PRINT ROOM - FOR UTM 10 BE RULED - DA-23 STAGE-1 LEVEL 3 PLAN.DWG - 11/12/2011 - 15:29

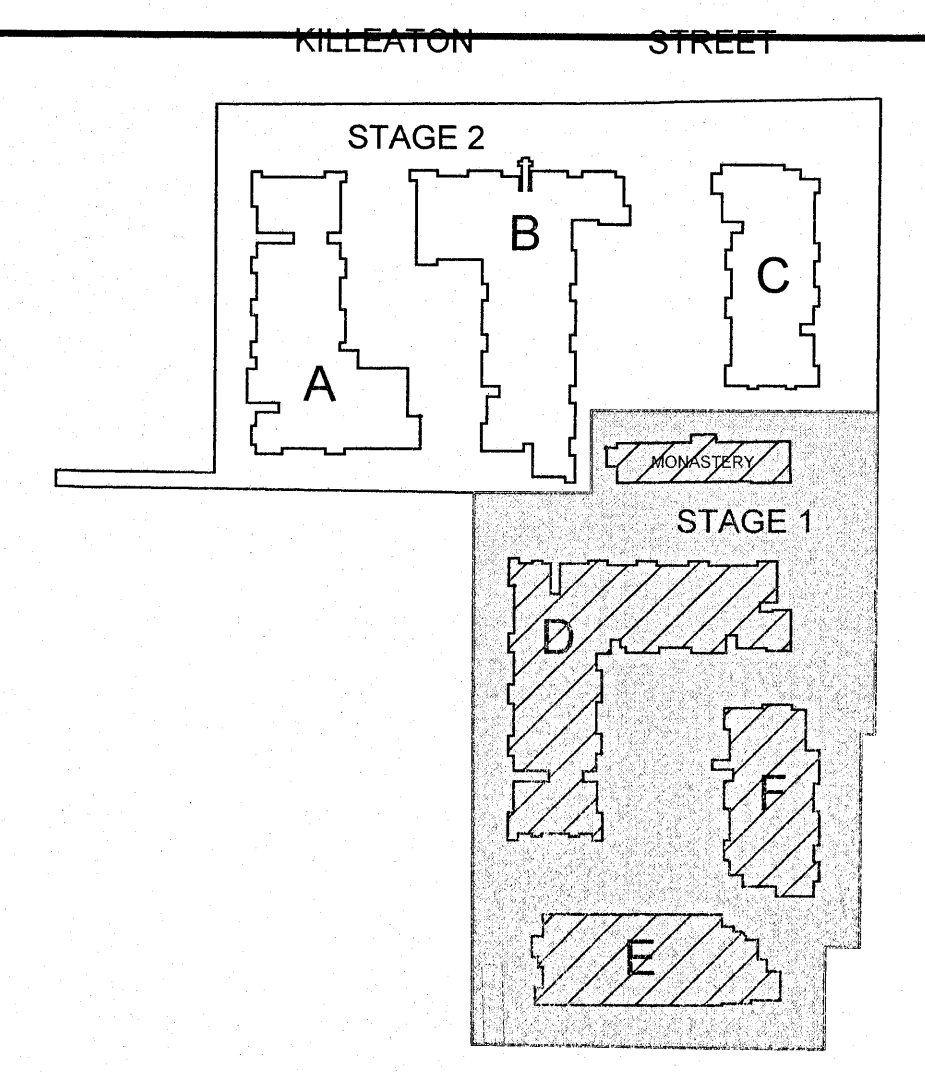
Drawing No.	Title	Proposed amendment
DA-21	Stage 1, Level 1	<ul style="list-style-type: none"> Block E correction to RL 162.4 (was incorrectly shown as 163.4 in original DA).
DA-23	Stage 1, Level 3	<ul style="list-style-type: none"> Show footprint of proposed pergolas to Block F.
DA-24	Stage 1, Level 4	<ul style="list-style-type: none"> Show footprint of proposed pergolas to Blocks D and E. Show overhead of pergolas to Block F. Amend plant – construct boiler room and retain remaining screened AC enclosure Block F.
DA-25	Stage 1, Level 5	<ul style="list-style-type: none"> Show Block F amendments described above. Amend plant – construct boiler room and retain remaining screened AC enclosure Block E. Show overhead of pergolas to Block E. Show new raised skylight in Block E. Show footprint of proposed pergolas to Block D. Show removal of raised skylights in Block D.
DA-26	Stage 1, Level Roof	<ul style="list-style-type: none"> Show amendments described above.

DRAWING TITLE:  
**BLOCK F ELEVATIONS**

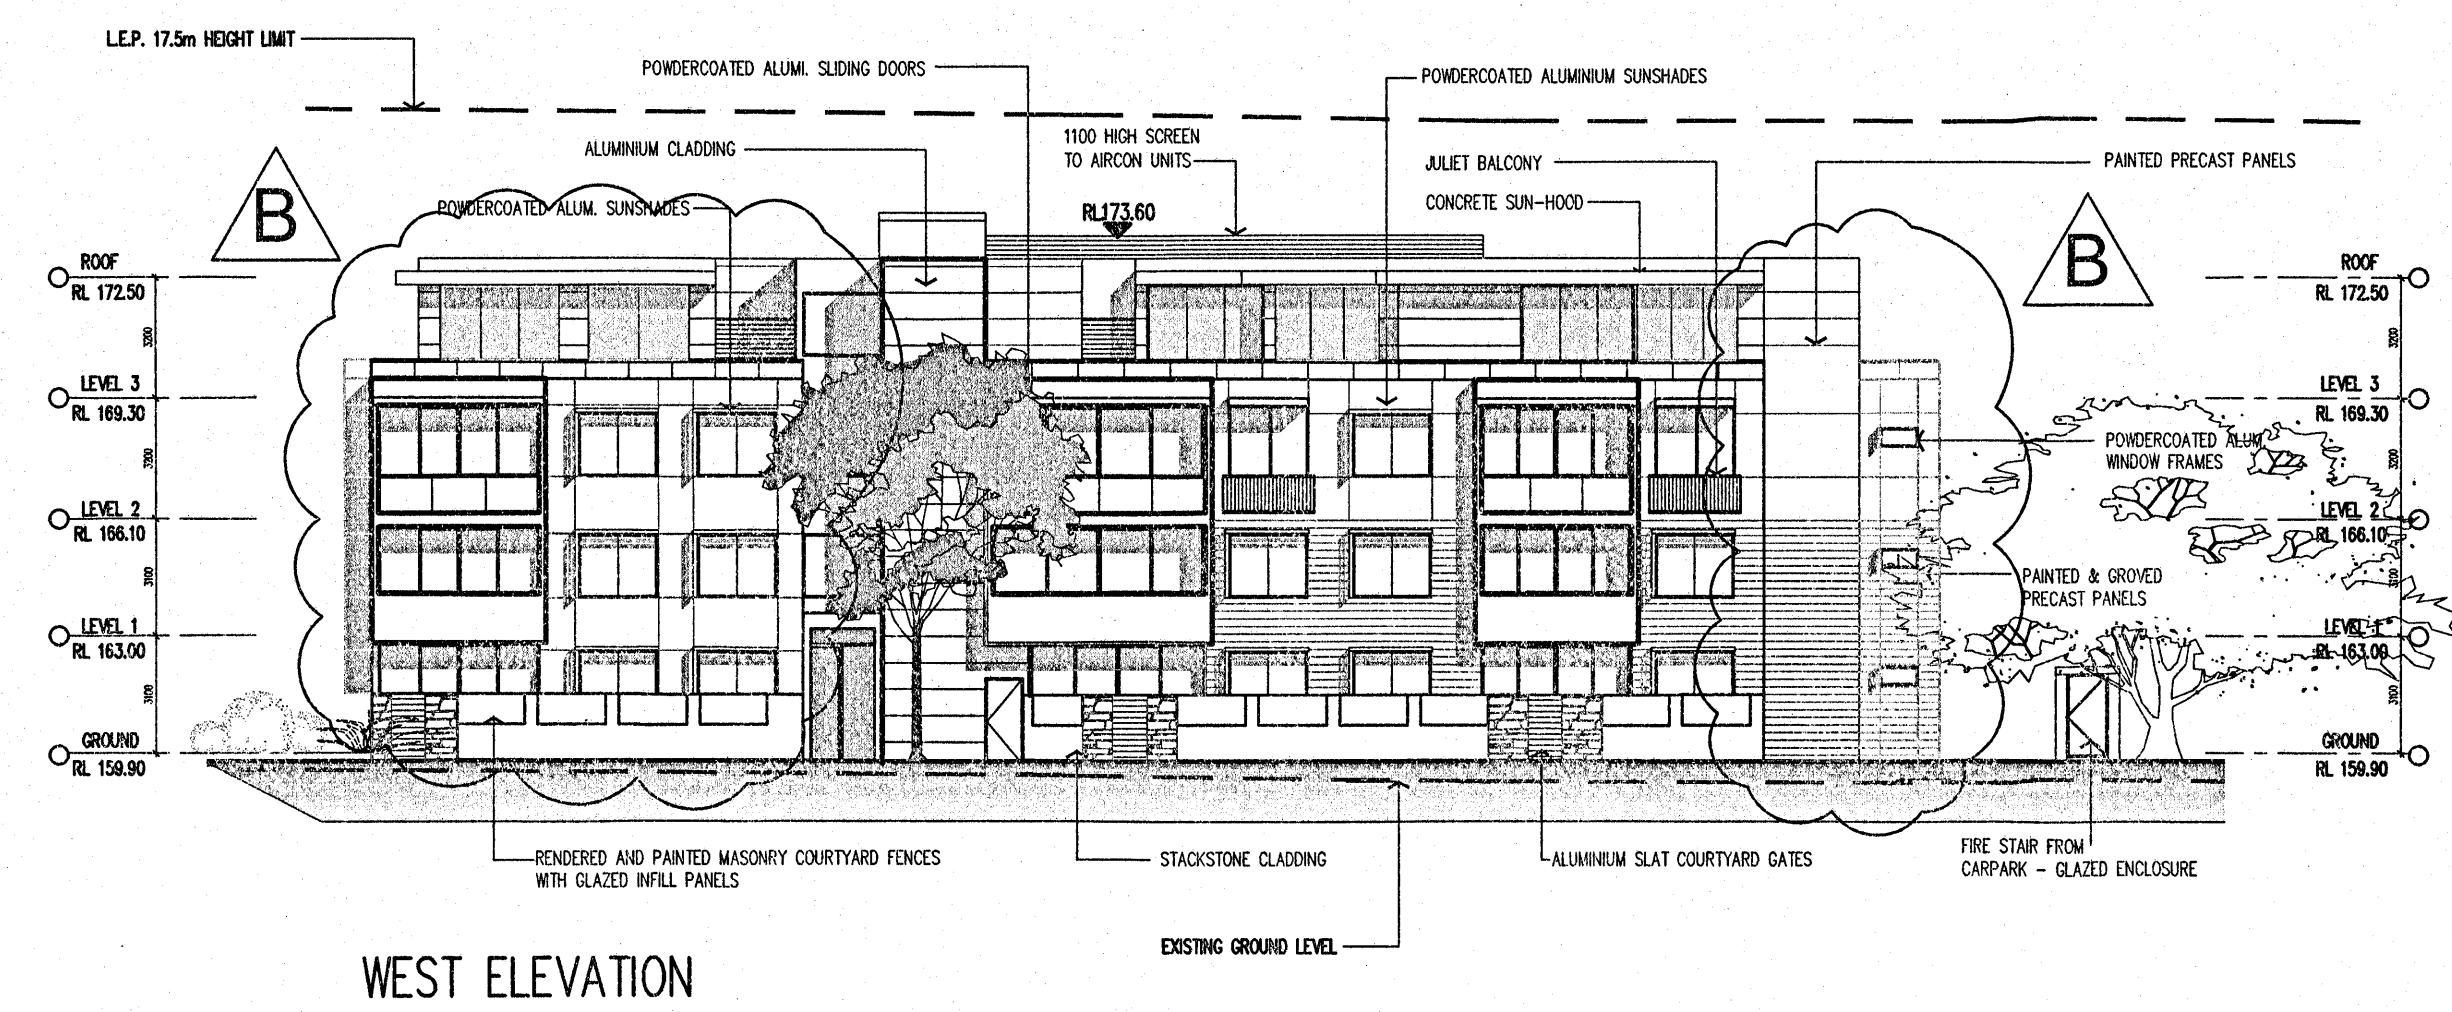
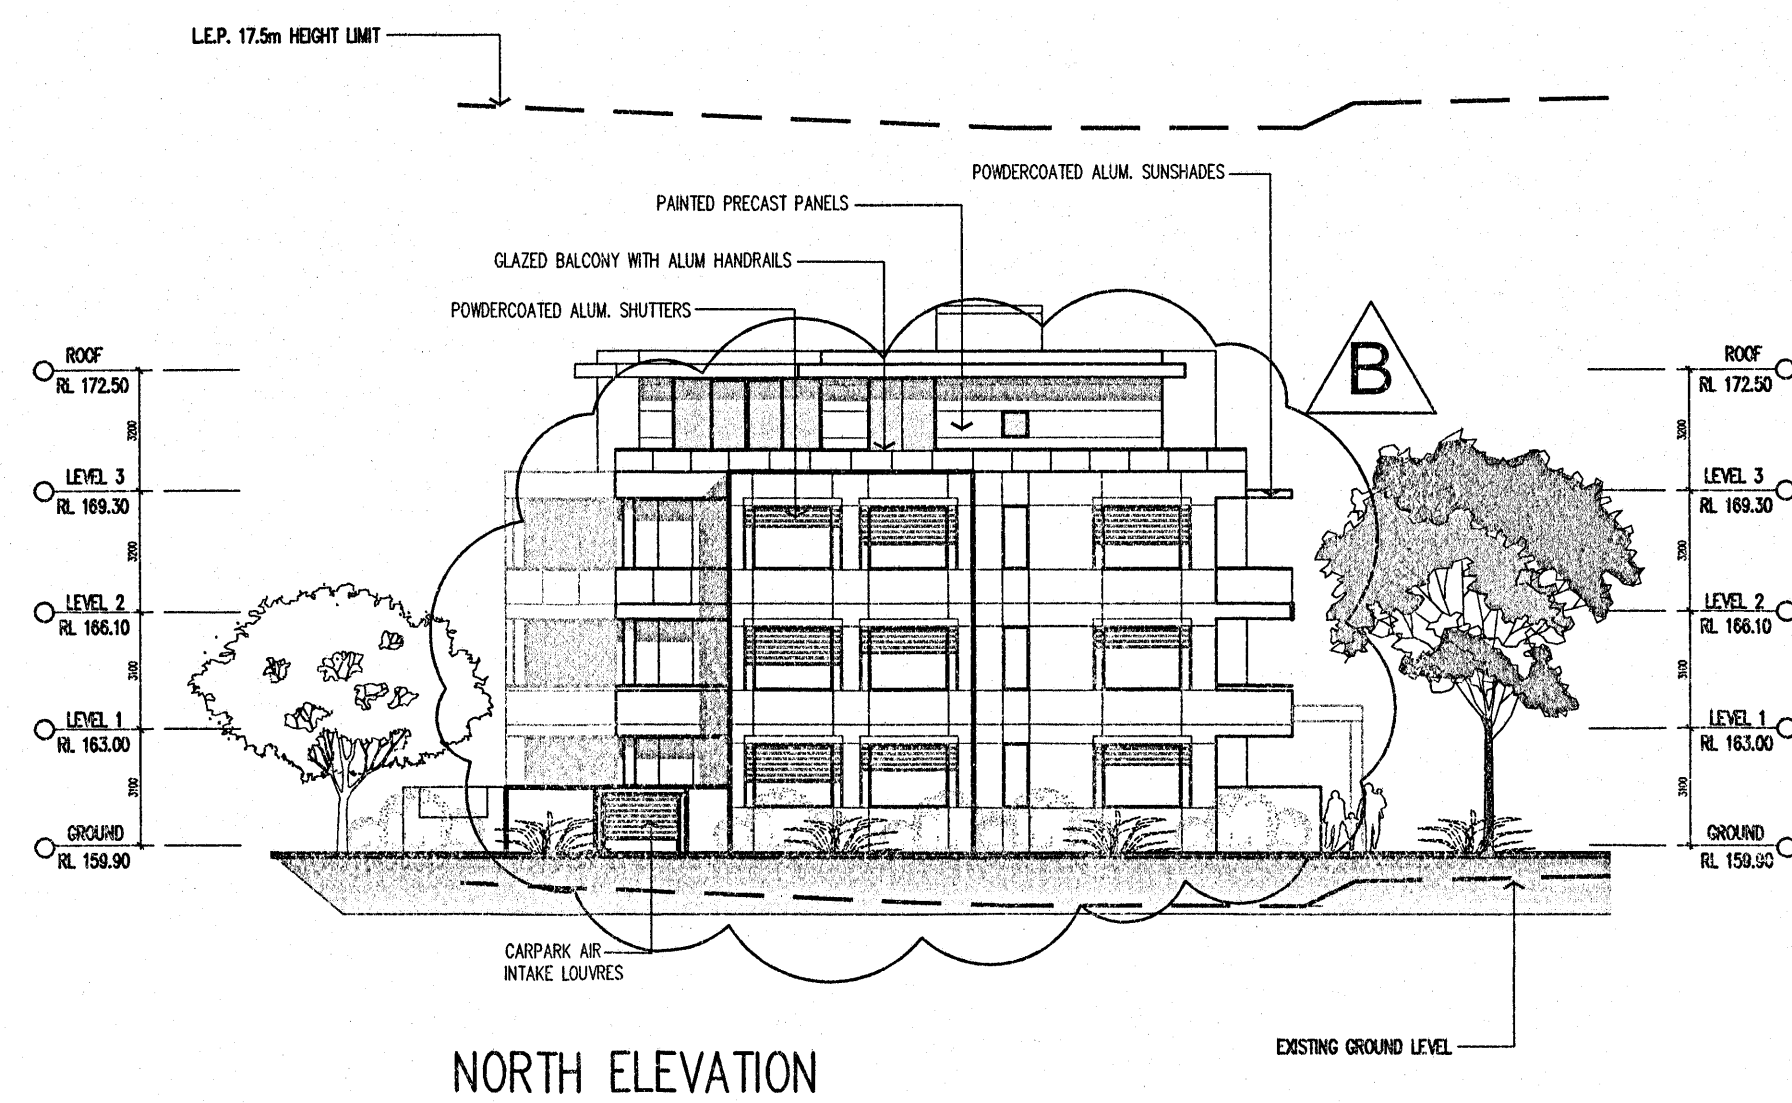
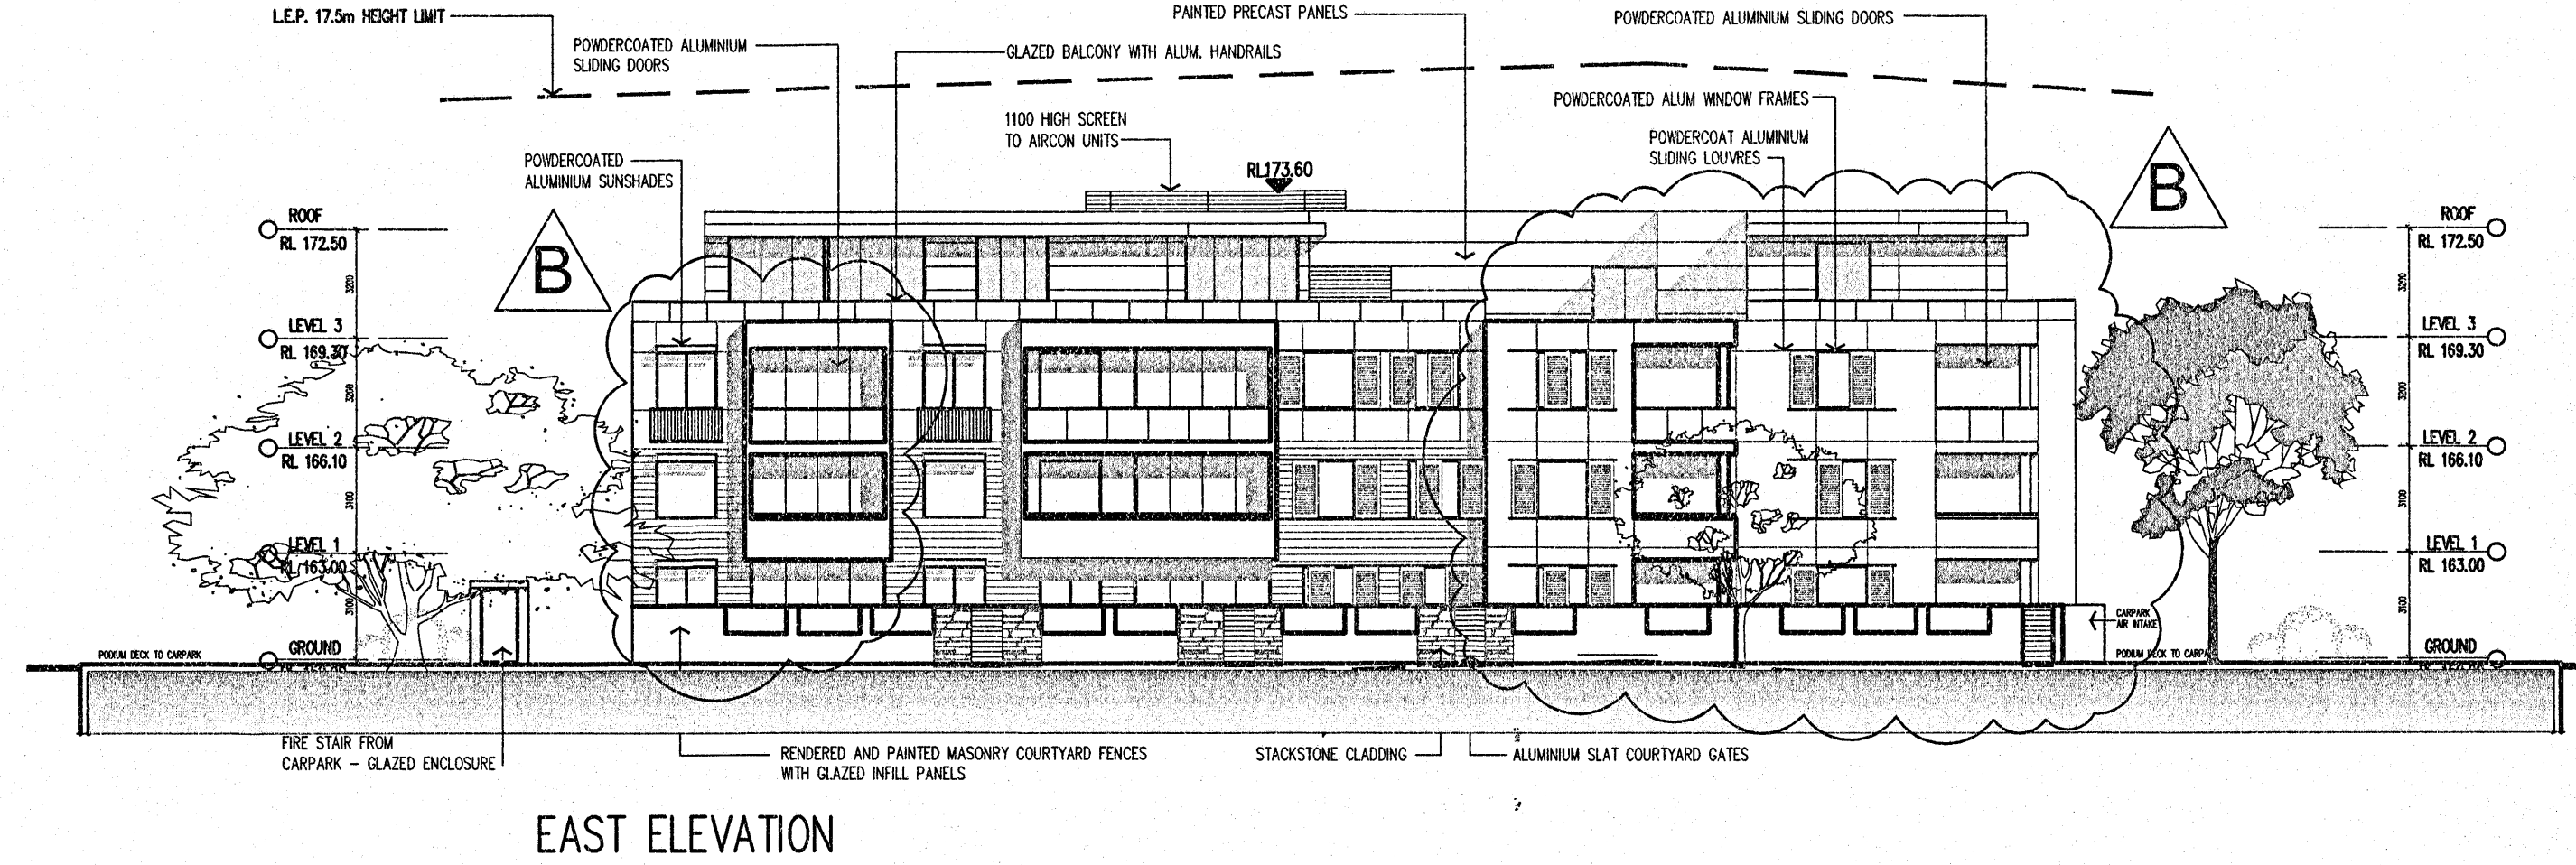
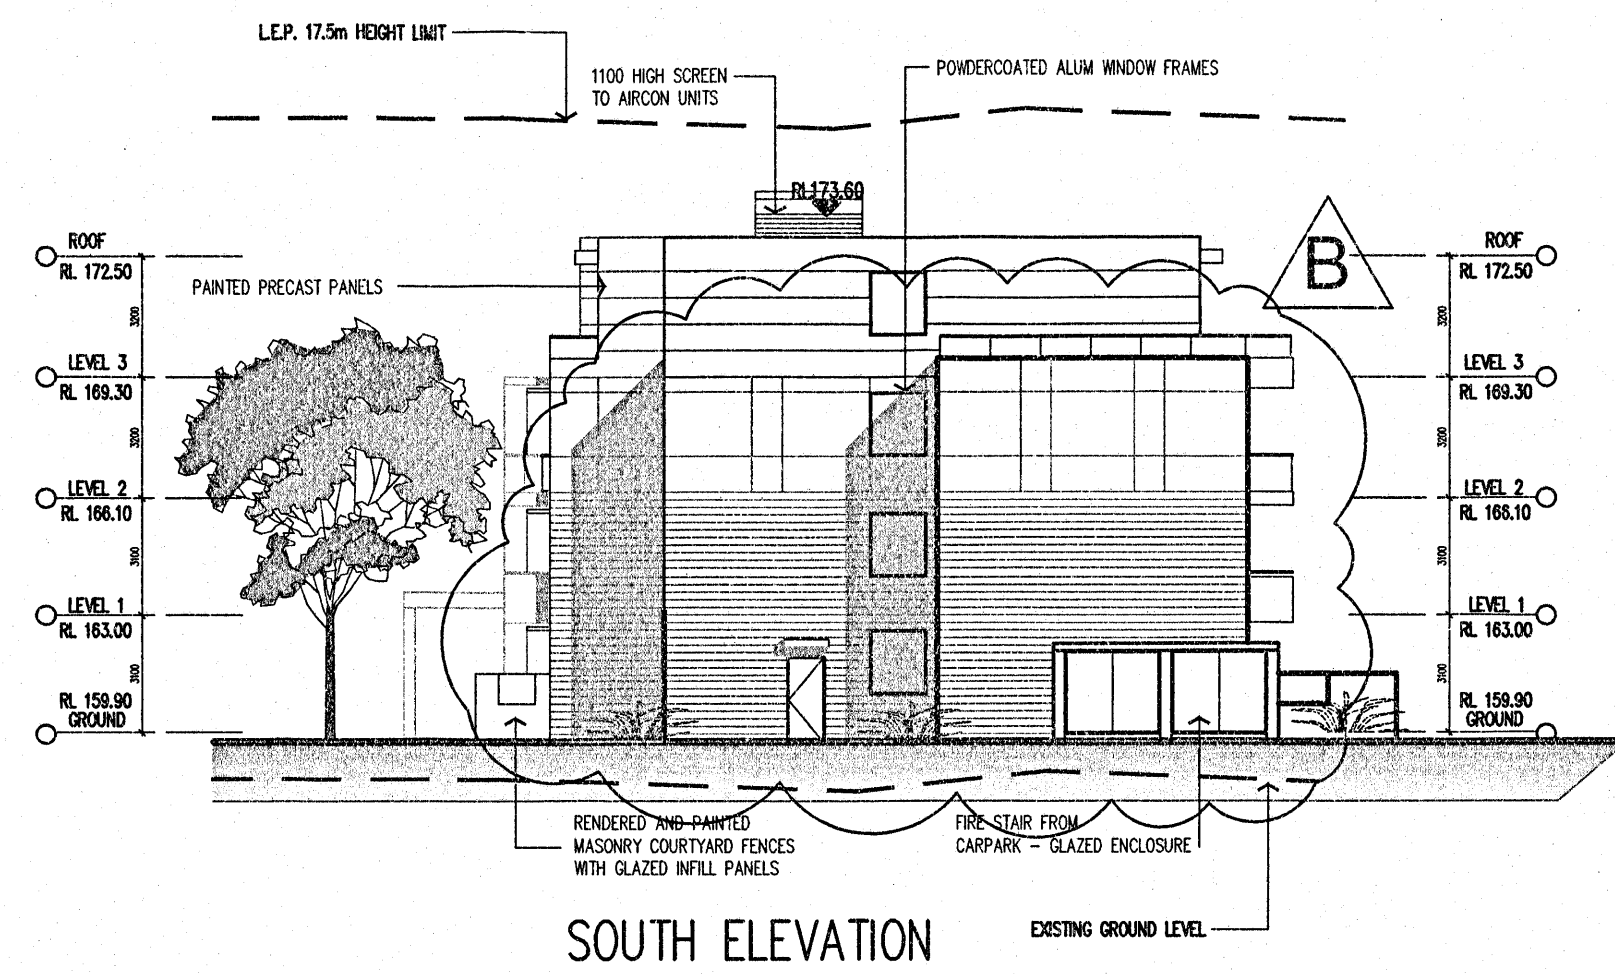
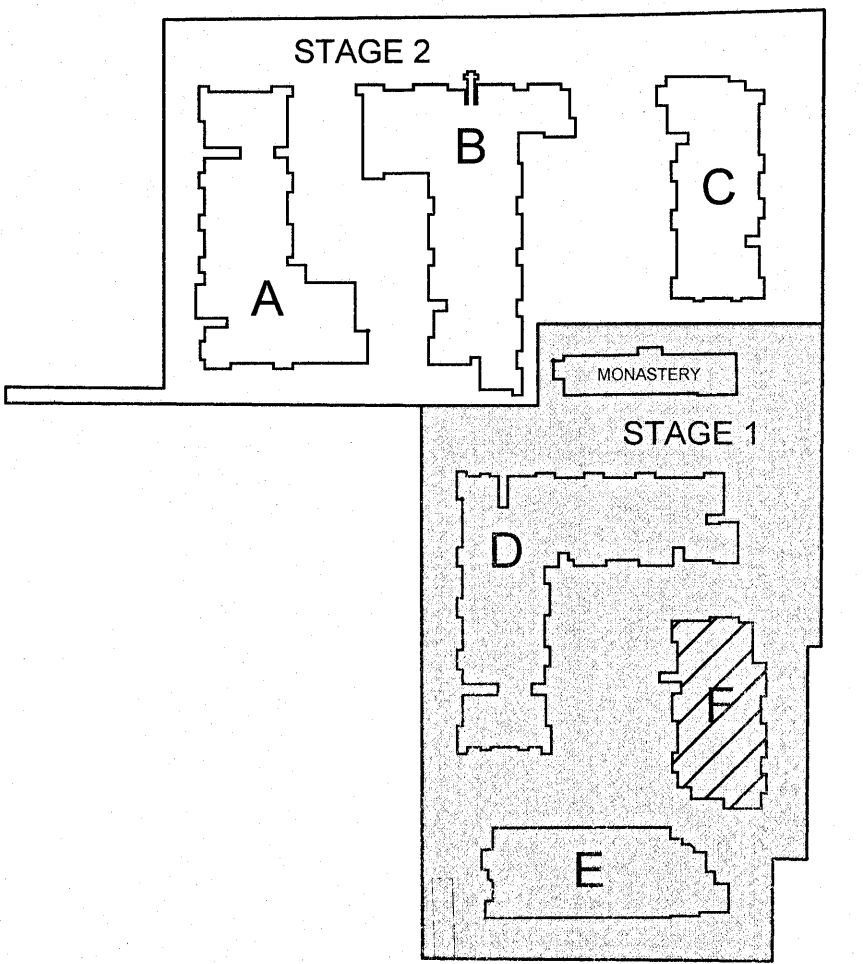
DA-44	Block E Elevations	<ul style="list-style-type: none"> Amend plant – construct boiler room (RL 177.50) and retain remaining screened AC enclosure. Changes described for Block A on plans DA-21, DA-24 and DA-25, above.
DA-45	Block F Elevations	<ul style="list-style-type: none"> Amend plant – construct boiler room (RL 175.00) and retain remaining screened AC enclosure. Changes described for Block A on plans DA-23 to DA-25, above.
DA-46	Site Section AA	<ul style="list-style-type: none"> Changes described above shown in section.
DA-47	Site Section BB	<ul style="list-style-type: none"> Changes described above shown in section.
DA-48	Site Section CC	<ul style="list-style-type: none"> Changes described above shown in section.
